**S73 VARIATION OF CONDITION 2 AND REMOVAL OF CONDITION 9 OF APPLICATION  
3/2021/0595  
LAND AT PRESTON ROAD, RIBCHESTER PR3 3XL**

This application comprises a s73 application to vary condition 2 (plans) of Application ref. 3/2021/0595 and to remove condition 9 (off site highways works) on behalf of our client Mr T Ball. The application has been submitted via the Planning Portal (ref. PP-11287148 ) and comprises the following:

Proposed Building ELEVATIONS

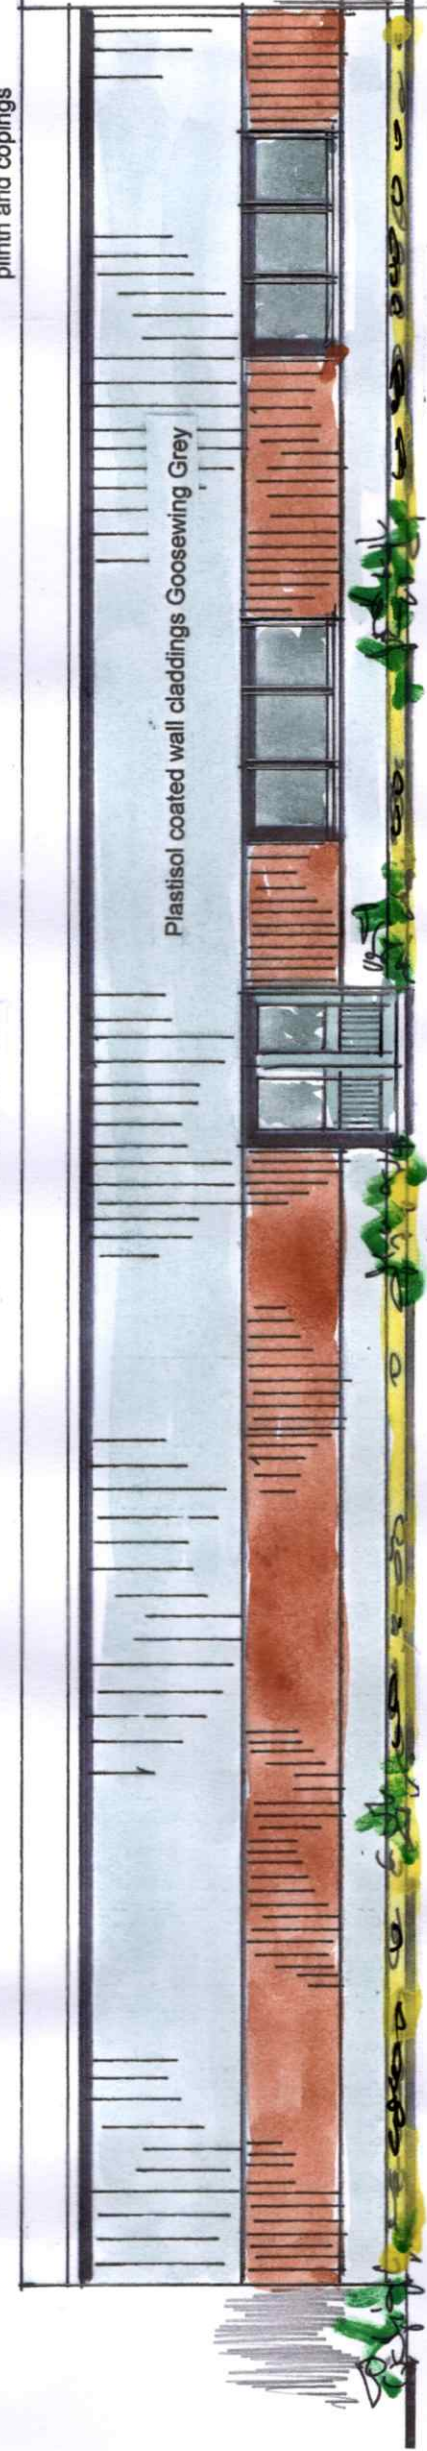
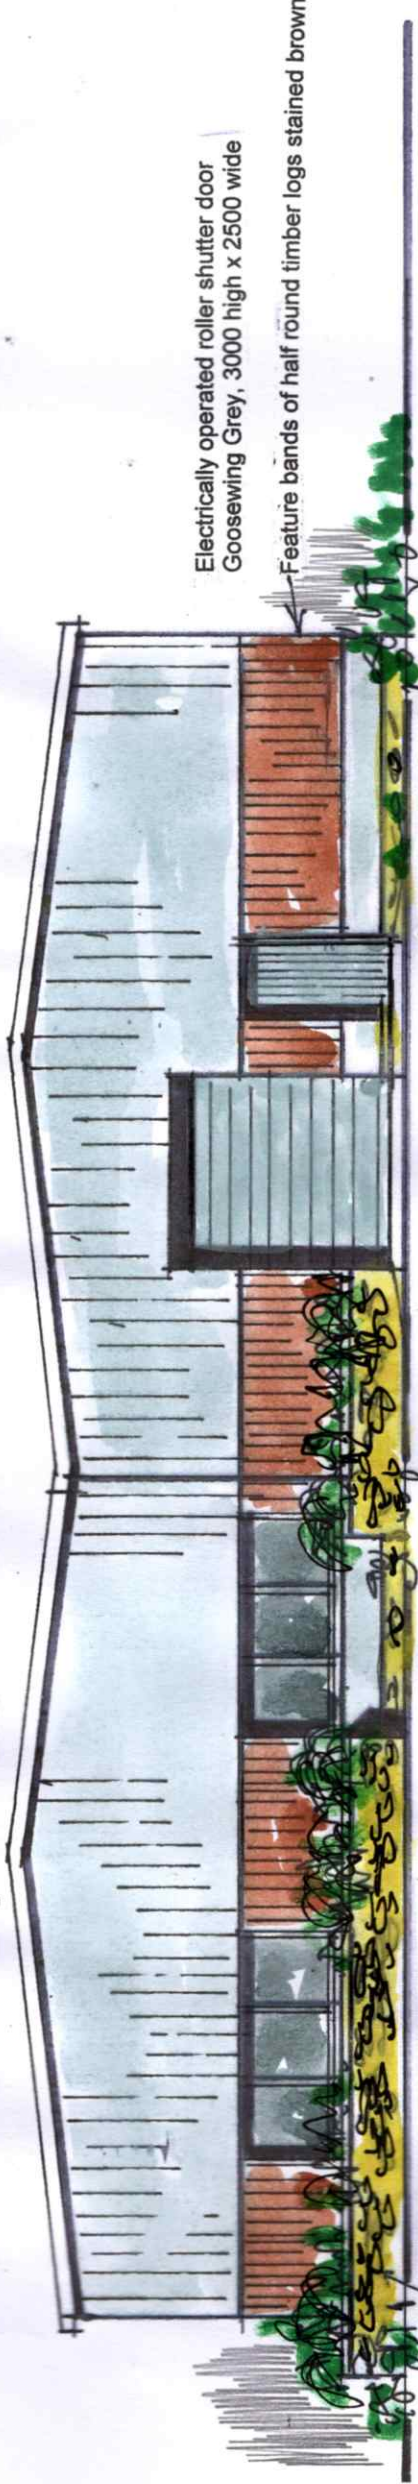
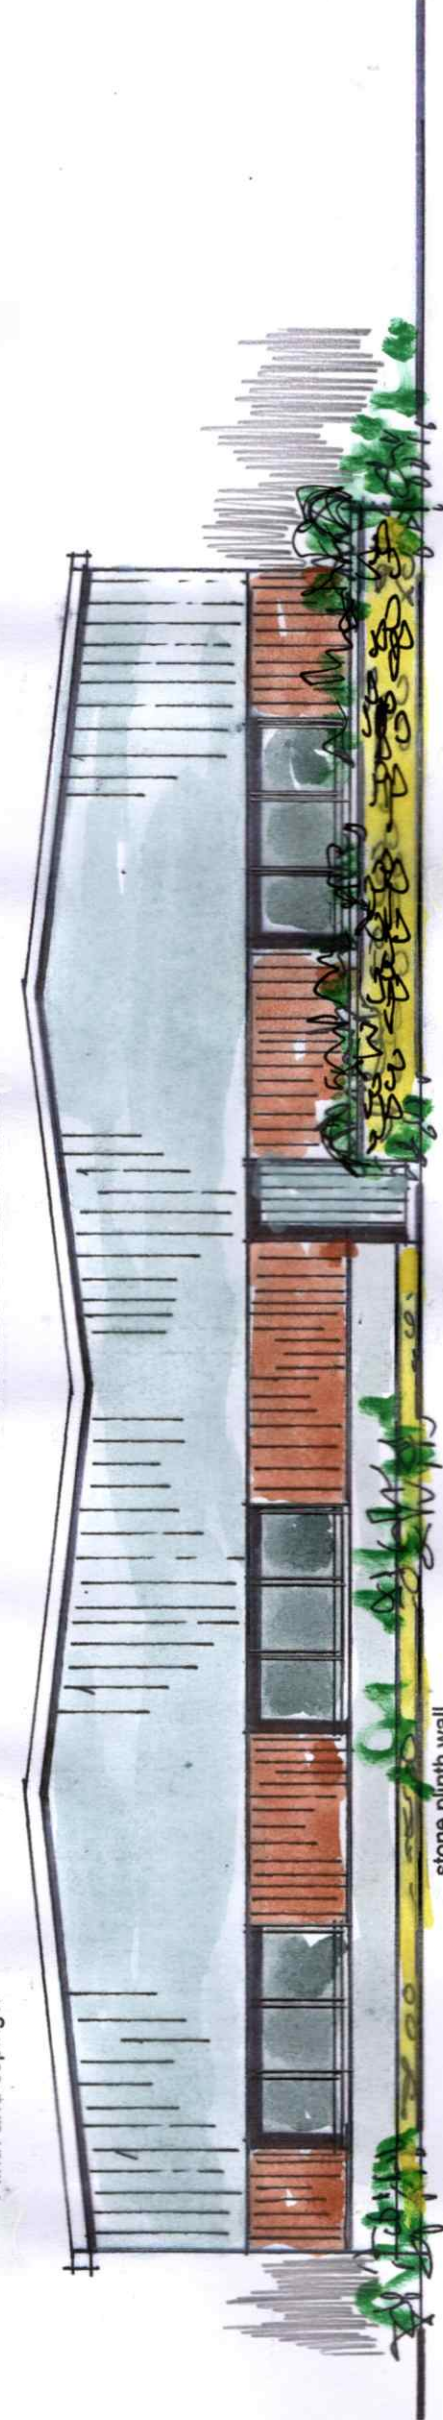
With regard to materials, my client has listened to the concerns raised in relation to application 3/2022/0271 and removed the previously proposed blue cladding. Instead my client proposes to use goosewing grey cladding with timber boarding. It is noteworthy that the original elevation drawing submitted as part of application 3/2021/05955 was not listed as an approved plan. Therefore, the materials shown on the elevation drawing 21/55/4 were not formally approved as part of the application. Given the location of the site it is hoped that the LPA will now share the client's view that the external appearance of the building is appropriate for its proposed use and location.

Proposed Building PLAN

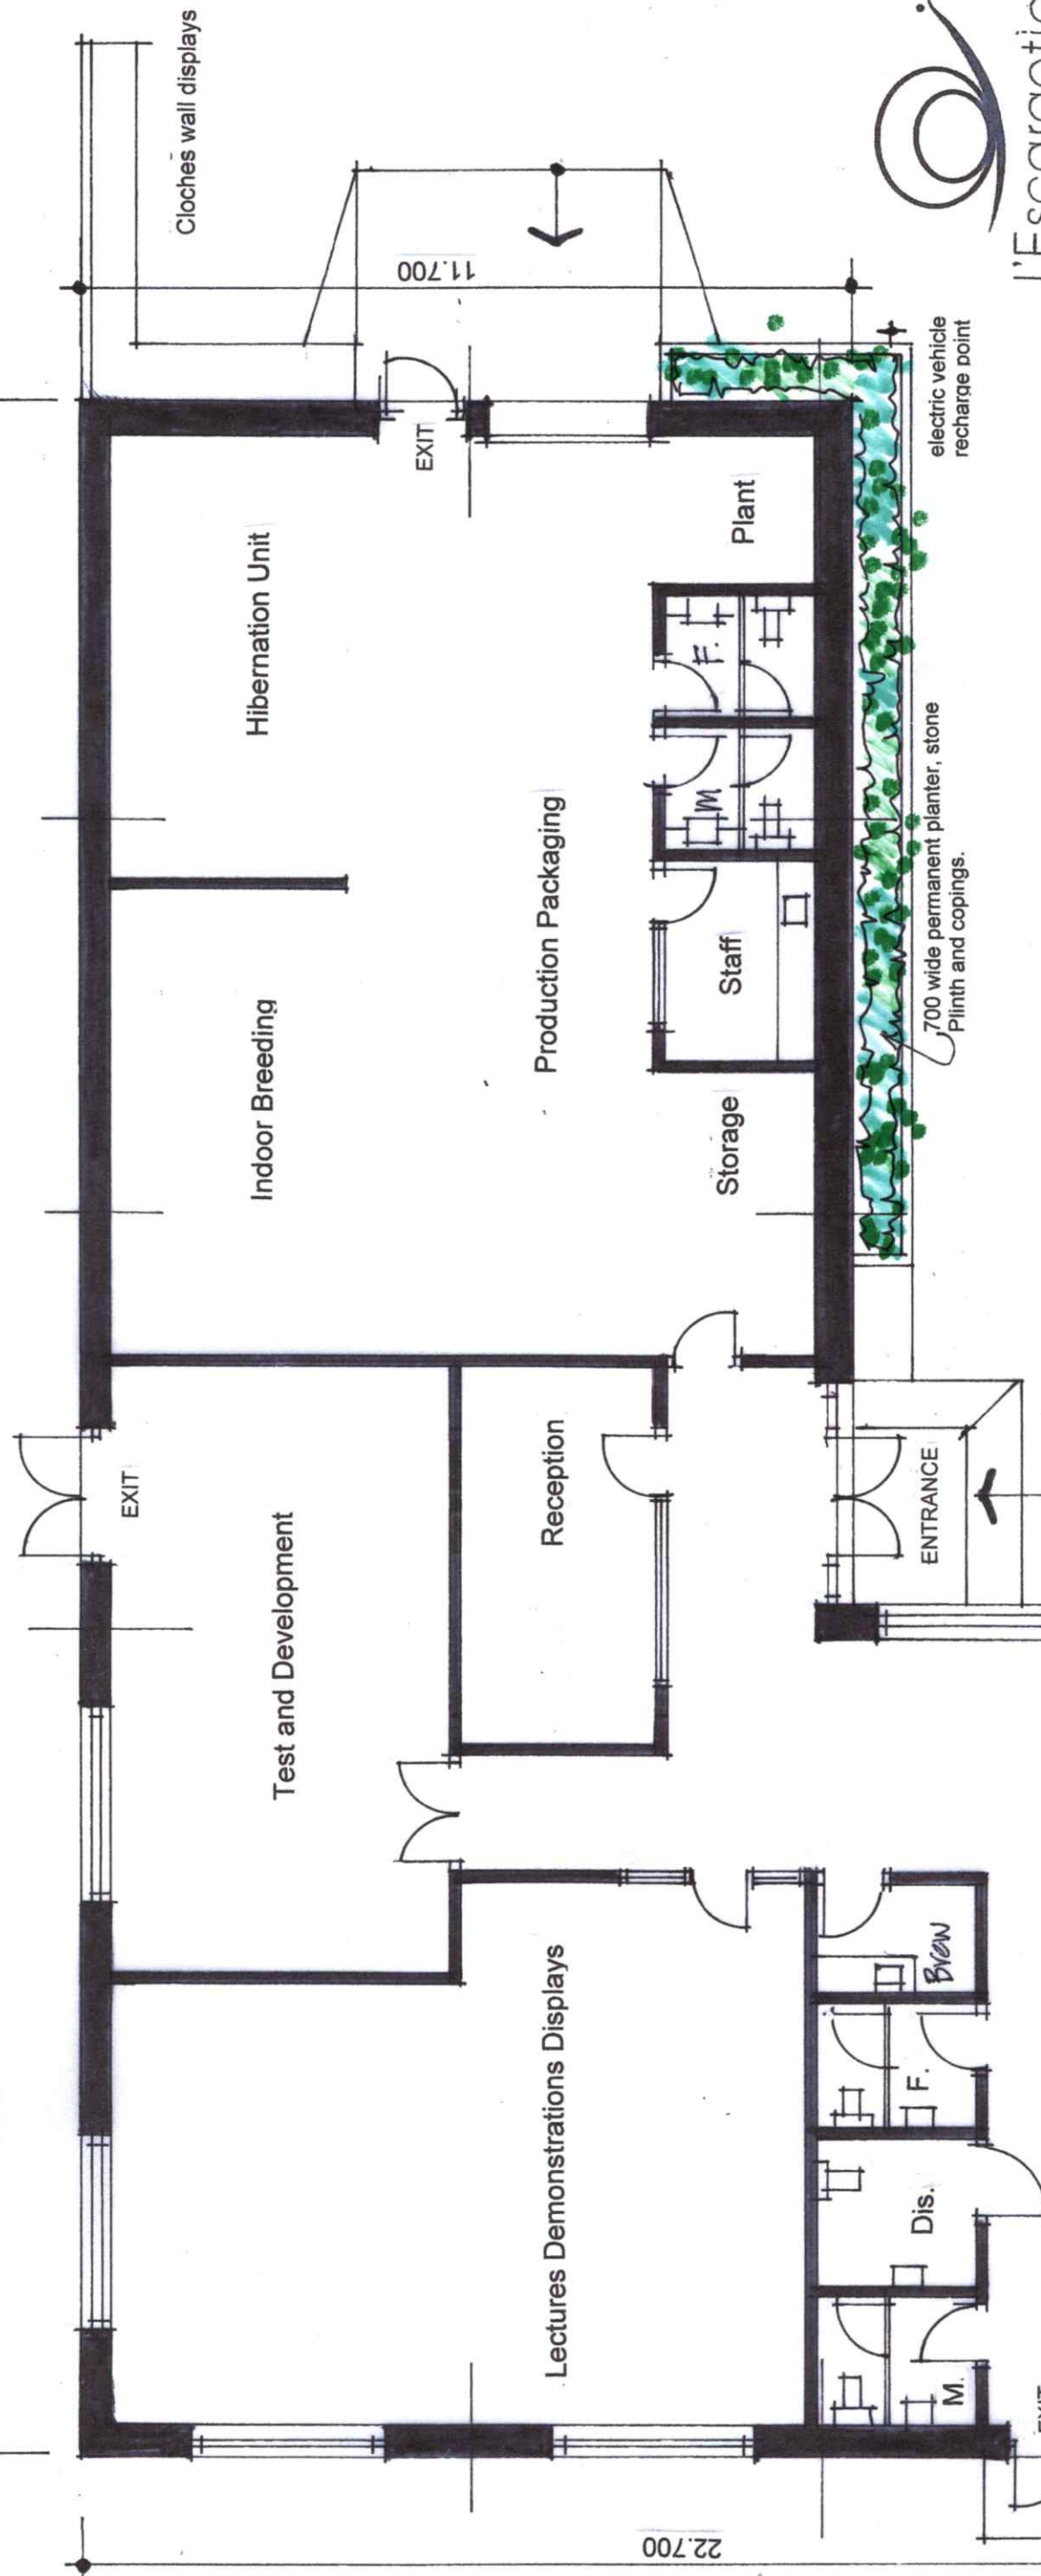
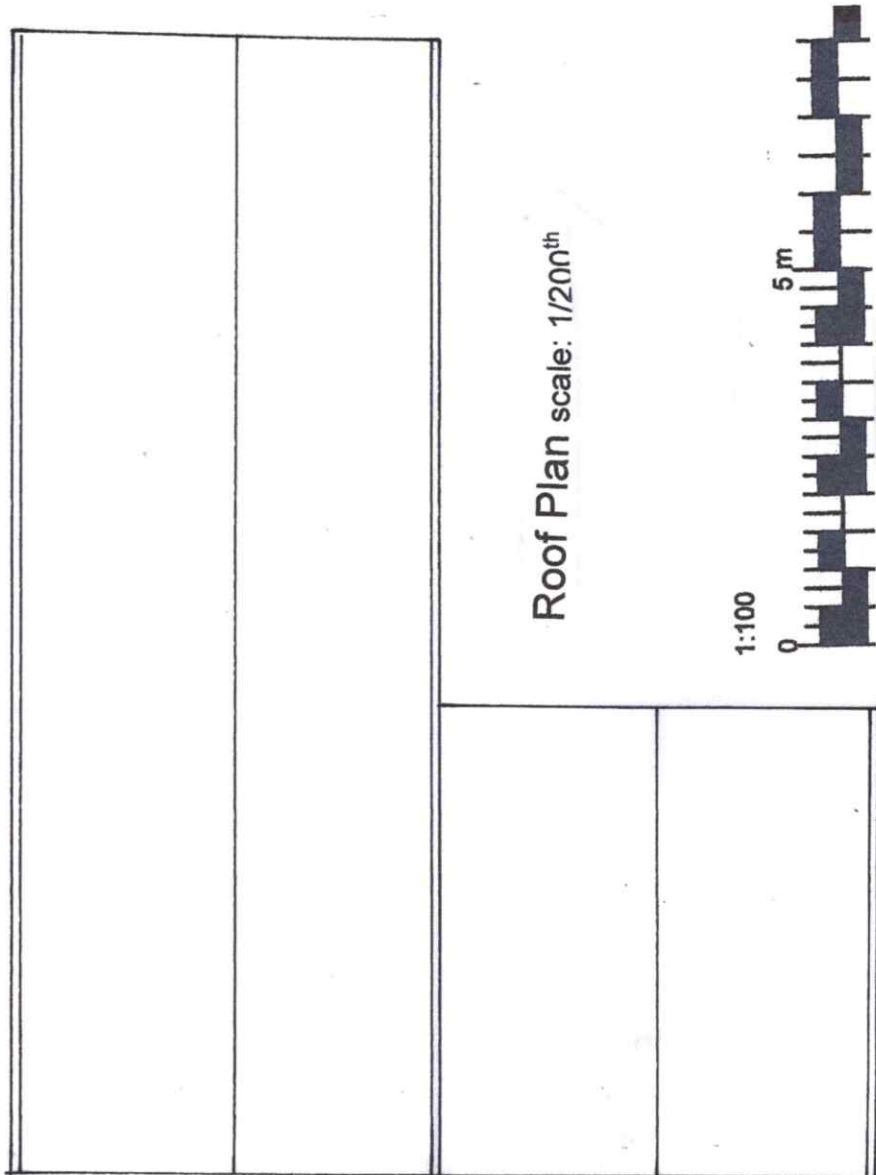
area to the east of the main building). My client has no intention to alter the use of the building as approved under 3/2021/0595. The building will remain as a building for heliculture and the lecture/demonstration area is to be retained. There is some minor reconfiguration within the building but no new uses are introduced. The reconfiguration has an impact on the external appearance of the building in that windows have been reconfigured and a roller shutter door and loading area provided to the eastern elevation to enable farm produce to be effectively distributed from the site.

**Proposed Development**  
**SITE LAYOUT**

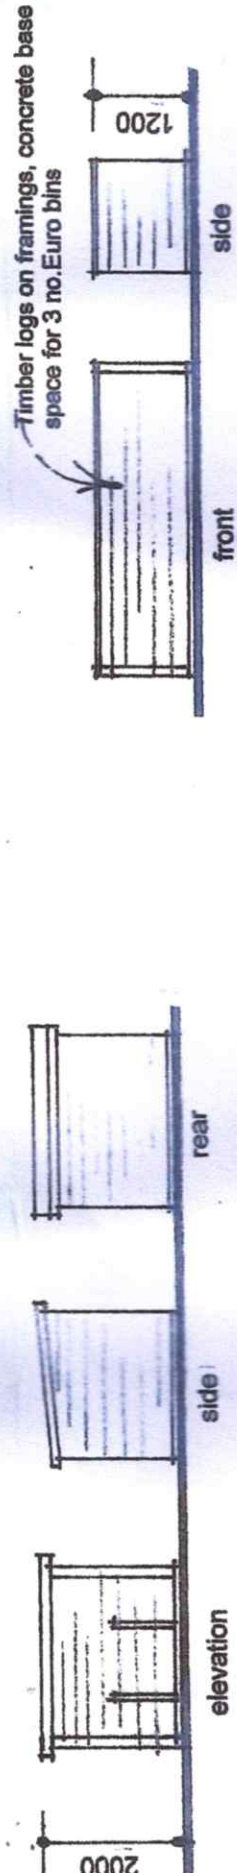
My client has given cognisance to the concerns of the LPA and local residents in this regard. This application no longer seeks to revise the layout of the approved holiday lodges and the site layout plan remains as previously approved in application 3/2021/05595 (except for the addition of a loading
